From: [Andrew Law](#)
To: [Keadby 3](#)
Subject: scoping consultation - Keadby 3 Low Carbon gas Power Station
Date: 26 June 2020 16:51:44
Attachments: [Coronavirusfooter11thMayB_6c3e8bc6-670e-4d10-bb1c-419a65888e95.jpg](#)
[SCO_2020_1_Keadby Power Station - HER.docx](#)
[SCO.2020.1_Keadby 3 EIA Scoping - ecology.doc](#)
[SCR-2020-1_Keadby Power Station - Environmental Protection.docx](#)
[Keadby 3 sopinq response - highways.pdf](#)
[Keadby 3 sopinq response - drainage.pdf](#)

Re: SCO/2020/1

SUBJECT: EIA Scoping Report for The Keadby 3 Low Carbon Gas Power Station Project, Land at and in the vicinity of Keadby Power Station site, Trentside, Keadby

Figure 2: HGV Designated Route Plan (Proposed Development Construction)

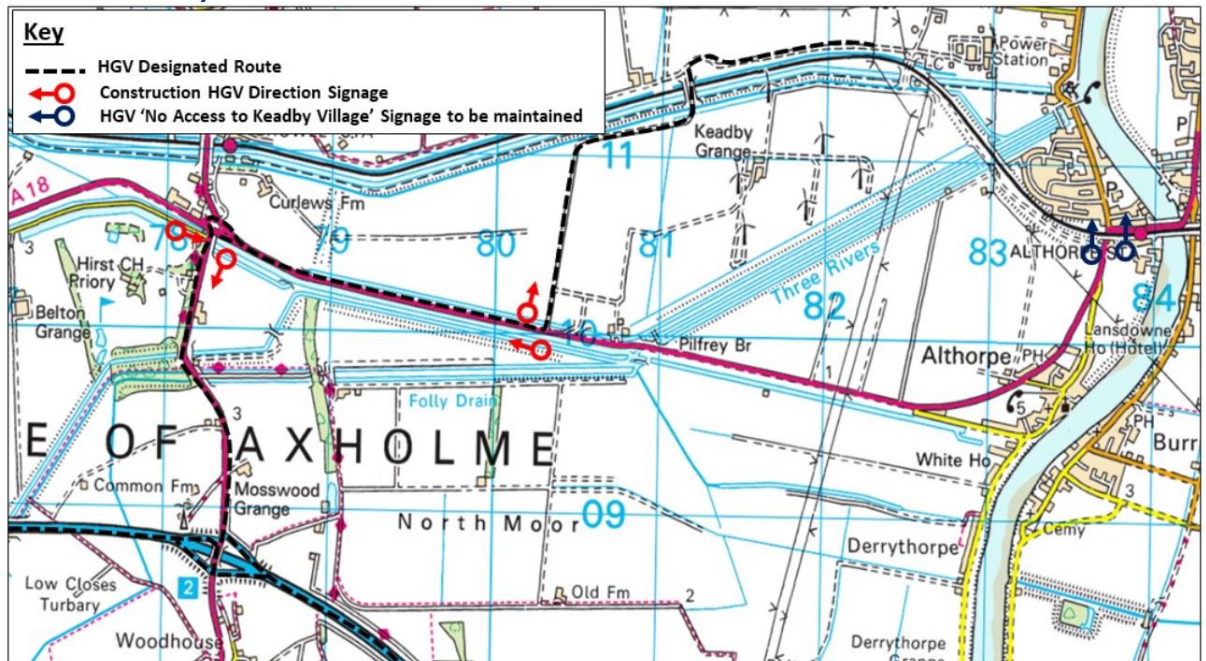
We would want to see all construction traffic accessing the site via the A18, not the B1392. Otherwise, I agree with the approach set out in the Traffic and Transport section of the report.
